Arun District Council
Arun Civic Centre
Maltravers Road
Littlehampton
West Sussex BN17 5LF
Planning & Building Control General Enquiries
Tel: (01903) 737756 Fax: (01903) 730442
Dx: 57406 Littlehampton
Minicom: 01903 732765
e-mail: planning@arun.gov.uk
website: www.arun.gov.uk/planning

Application No: FG/57/22/PL
Site Address: 12 Little Paddocks Ferring BN12 5NJ
Description of works: Demolition and erection of 1 No new dwelling. This application is in CIL Zone 4 and is CIL Liable as new dwelling.

Thank you for your internet representation made on 12th May 2022 which has been recorded as an objection with the comments as follows:

DRAWING No.
**Drawing 1
Existing & Proposed
Floor Plans & Elevations**

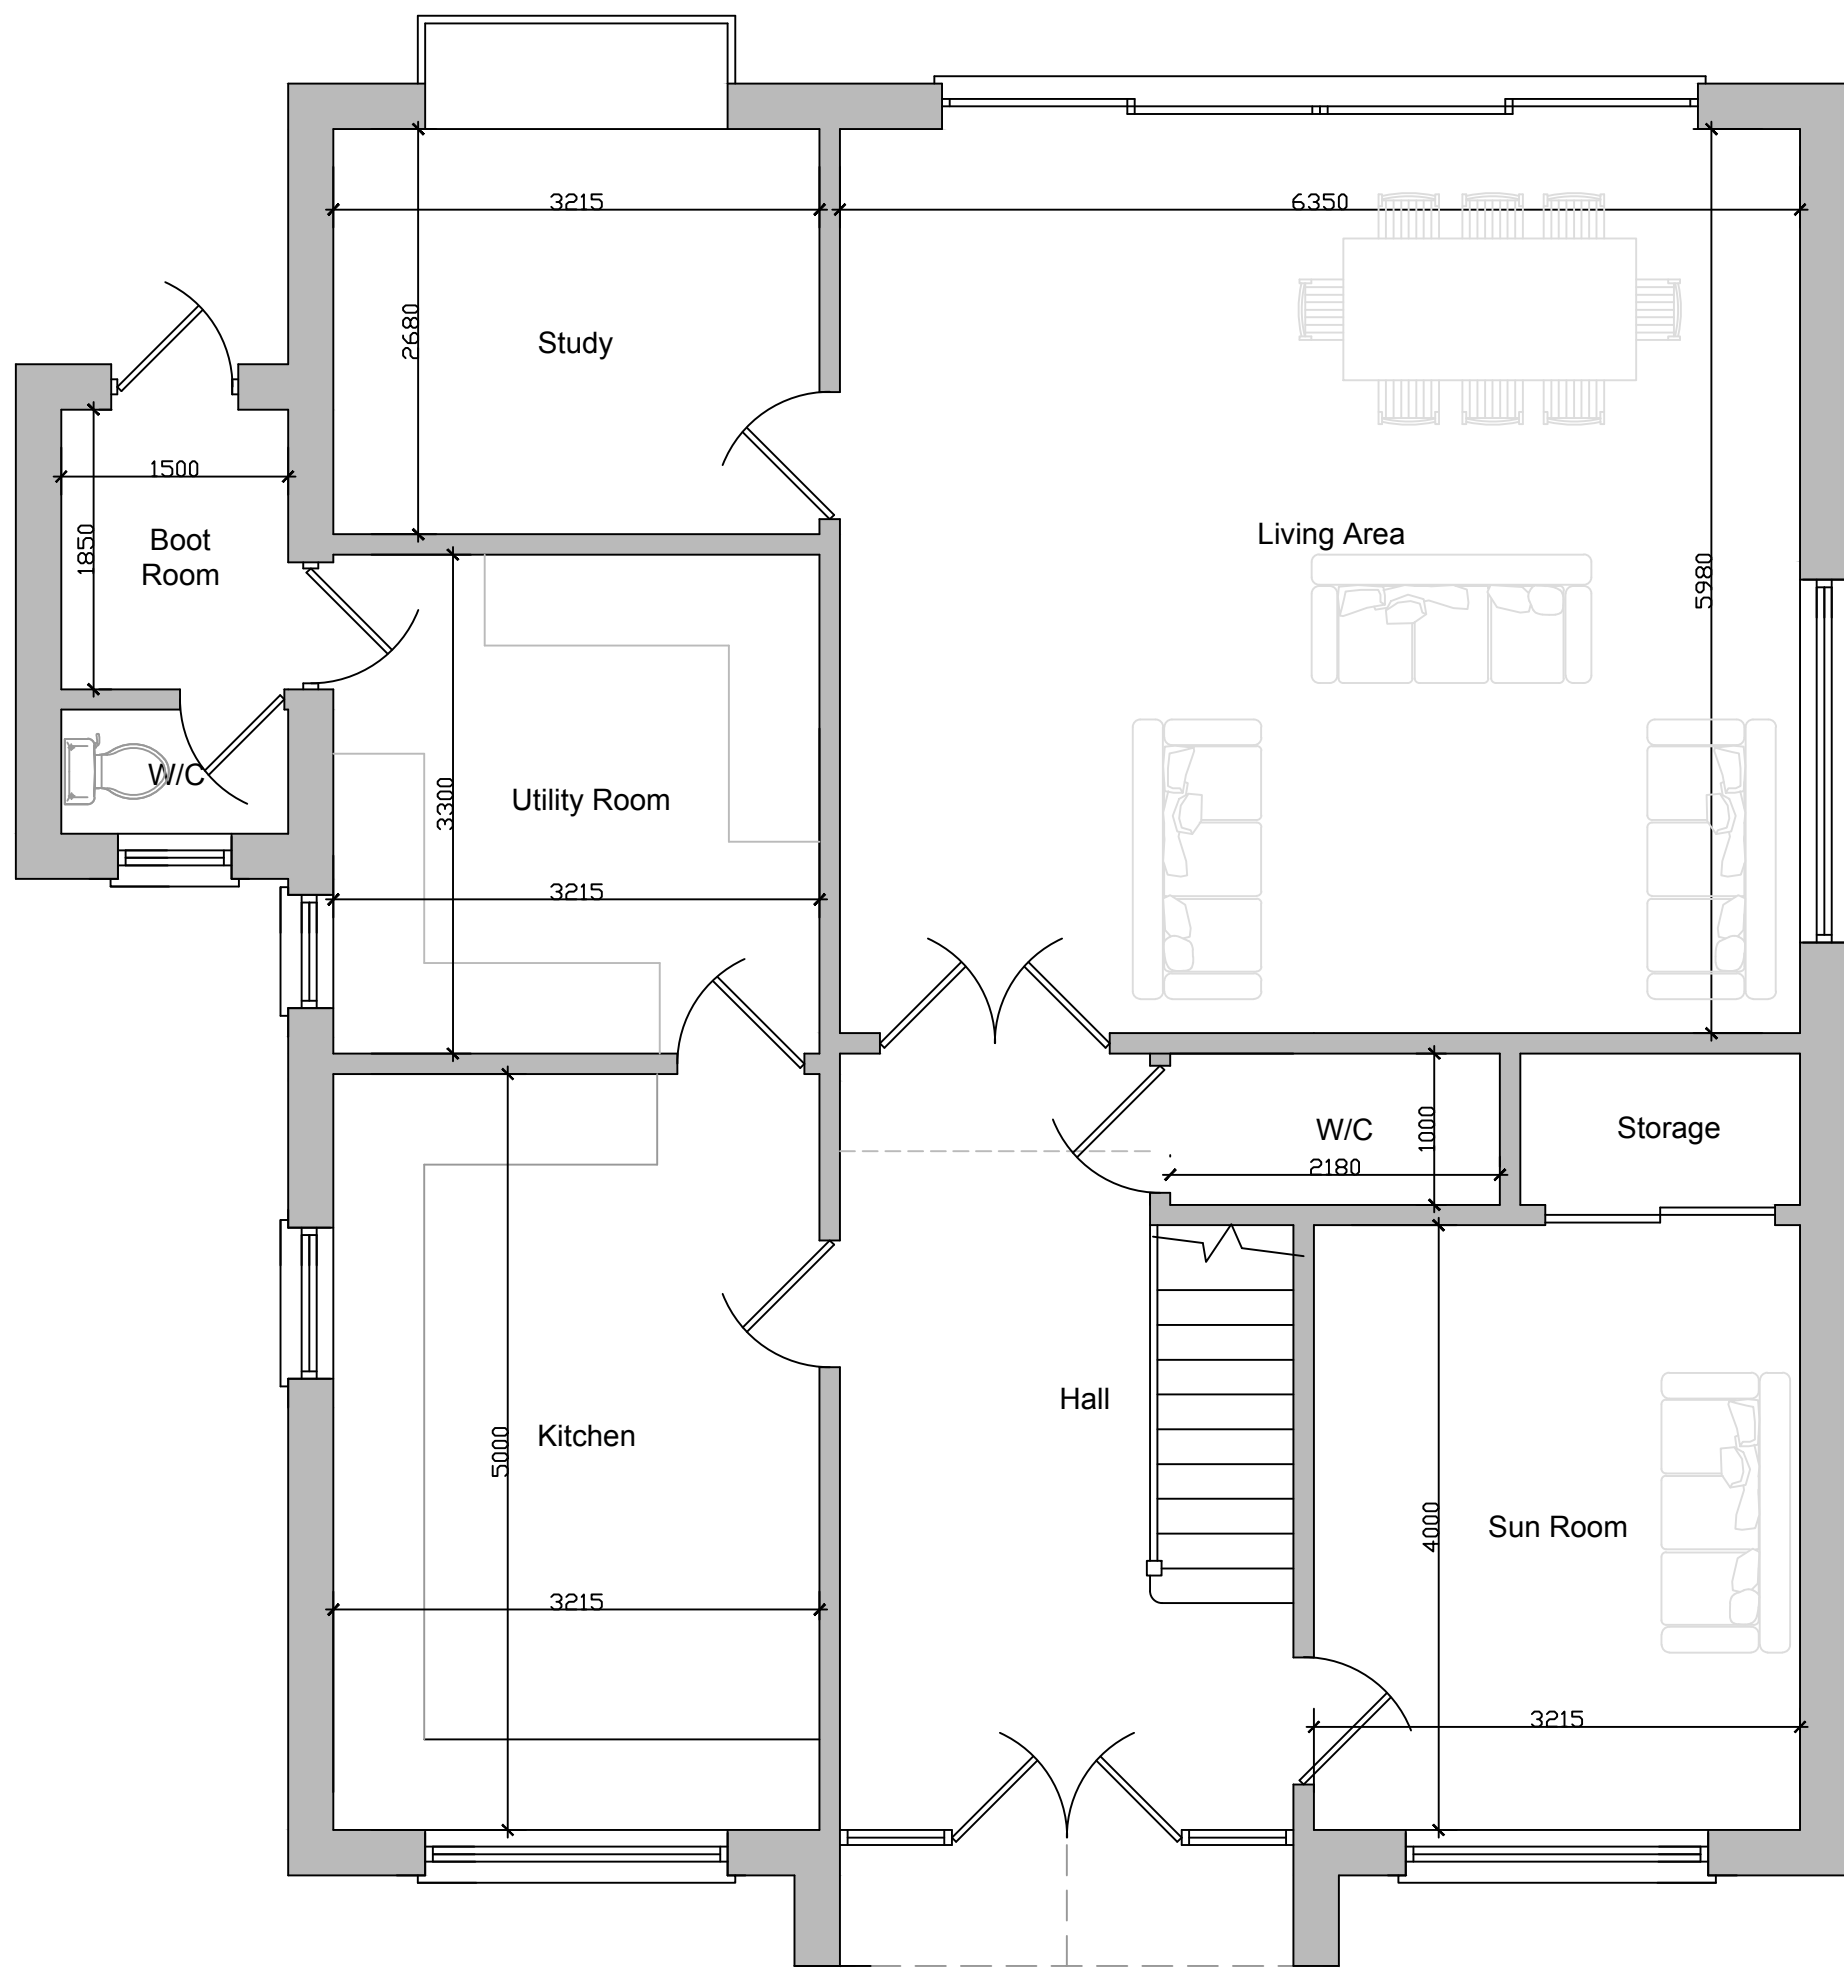
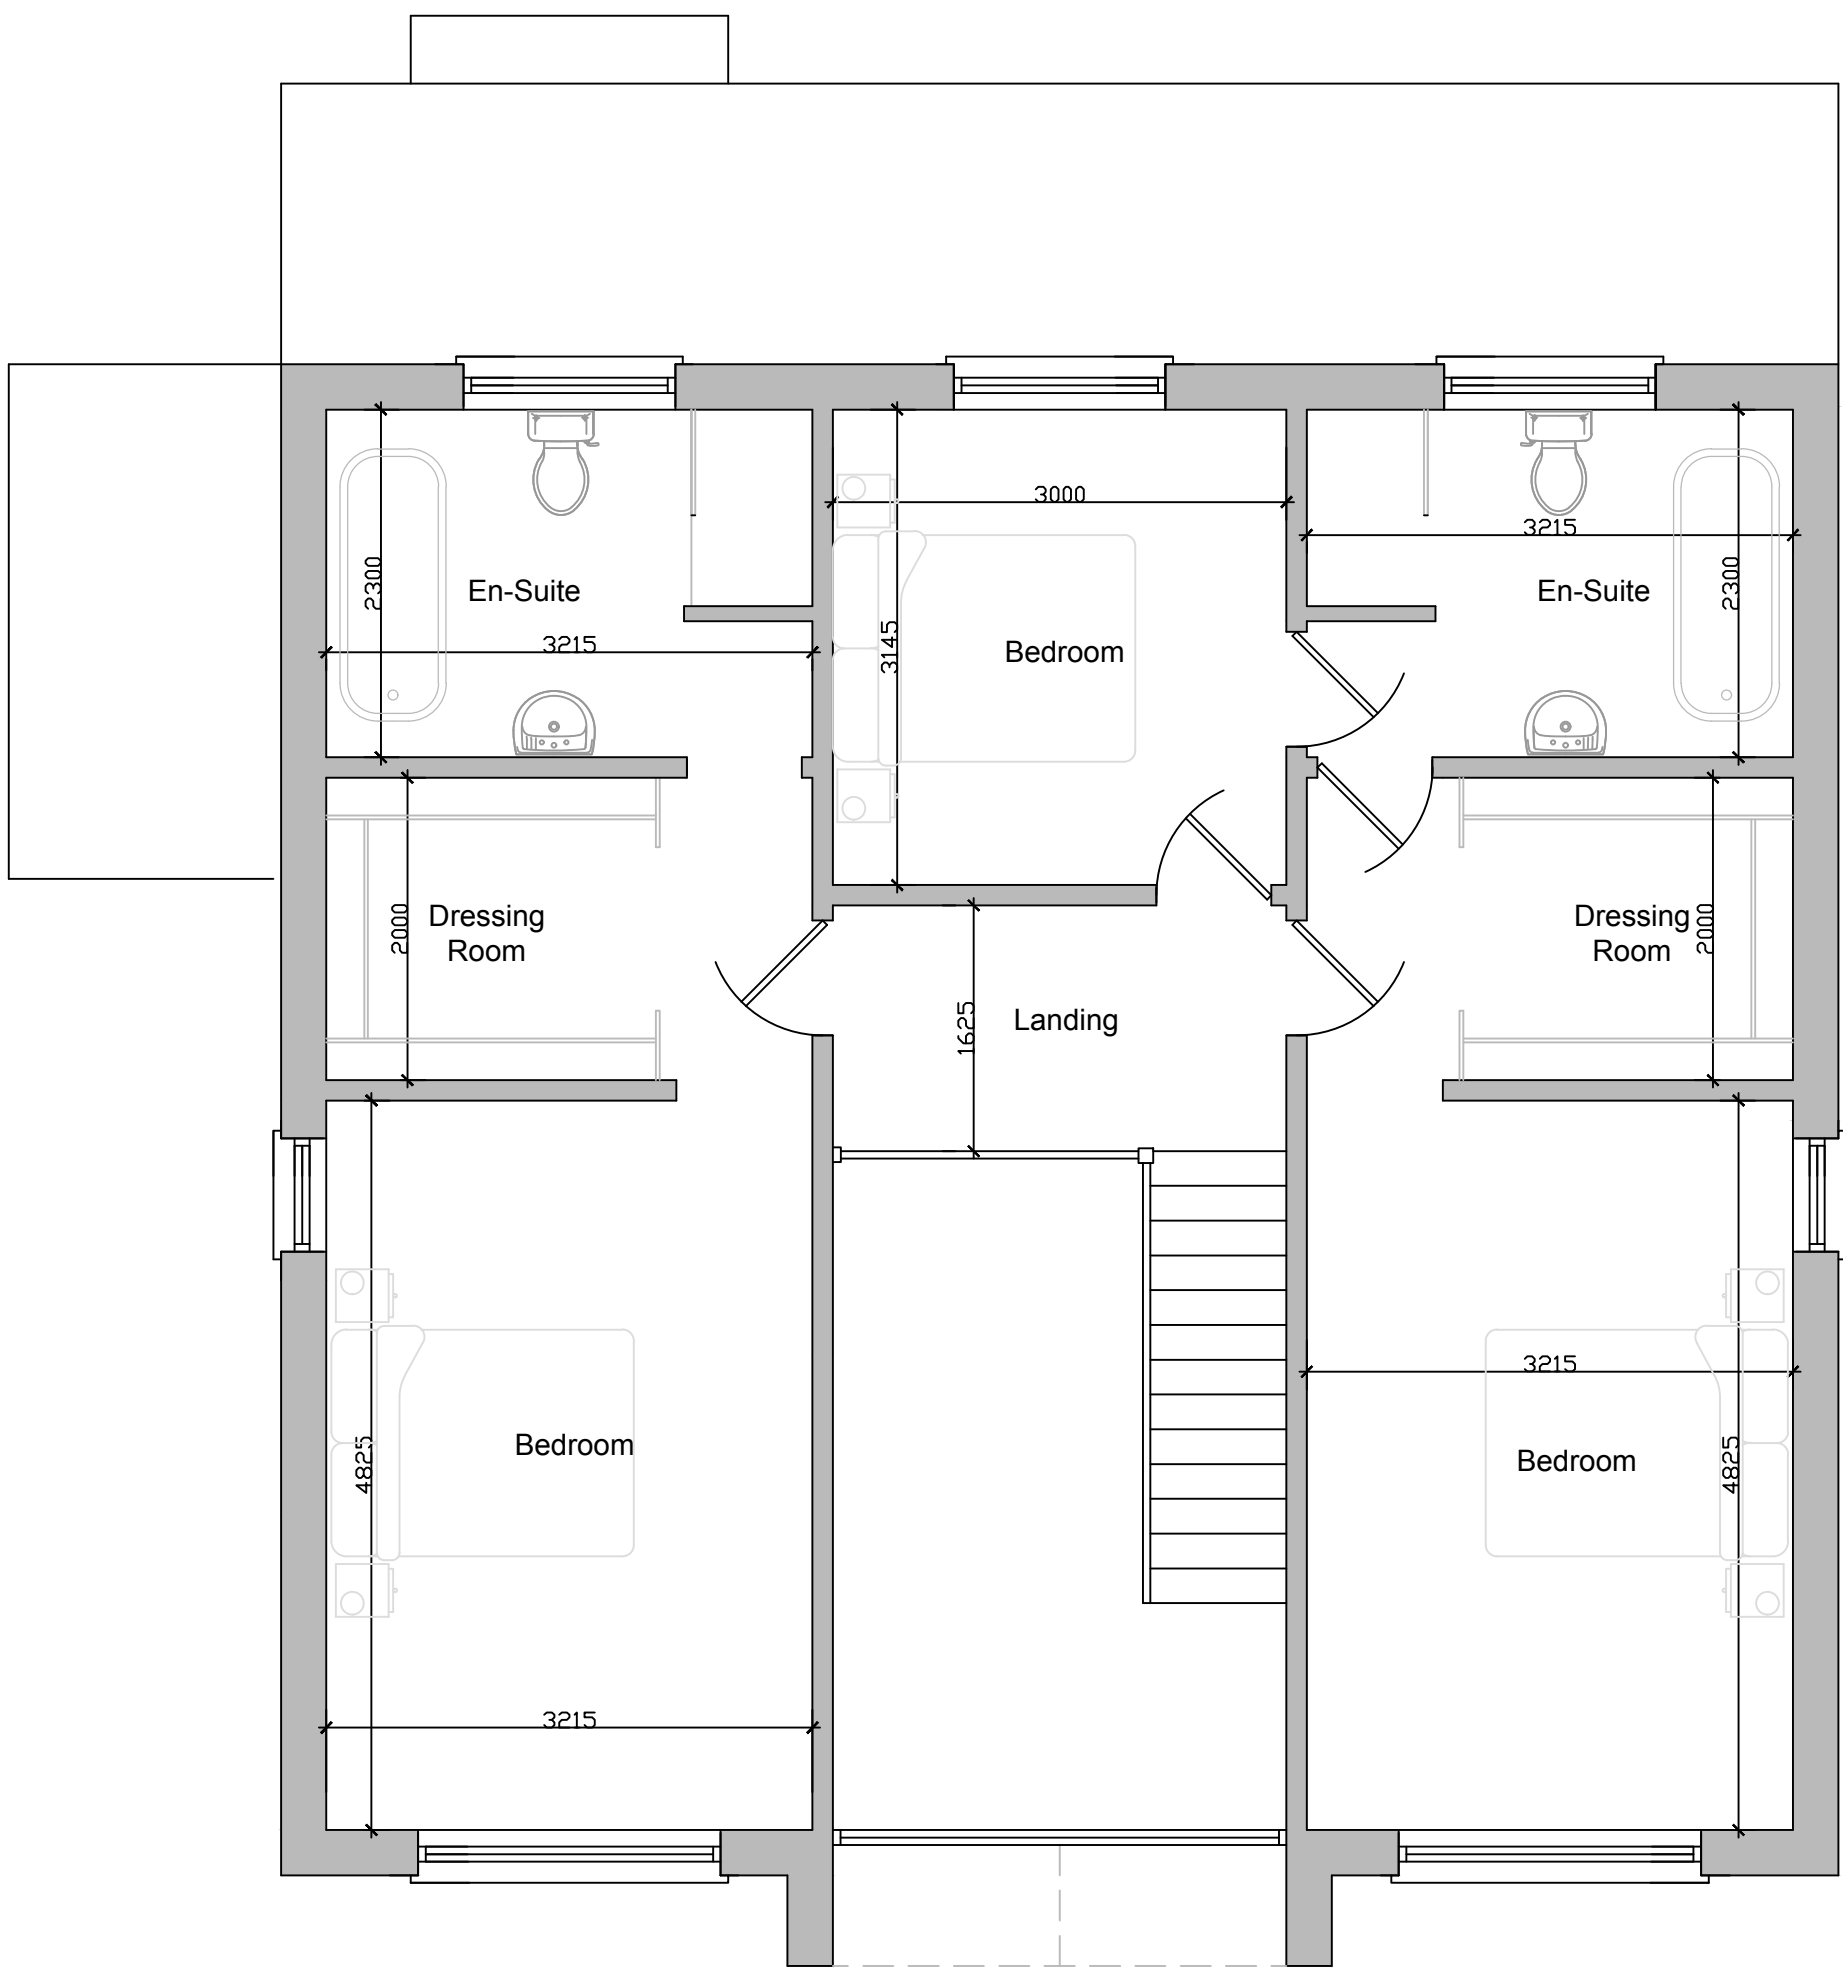
In respect of the actual plans, the drawings and images are not very clear or accurate. It doesn't for example, mention the height or how close it will be to the boundary.

Due to number 12 being on a corner plot, at a couple of points the building is very close to the boundary of the adjacent properties.

I have 2 west facing windows and a conservatory. On the whole, the views from them are of the sky and trees. A two-story box would compromise the views and overshadow my 1 story bungalow and impact my privacy.
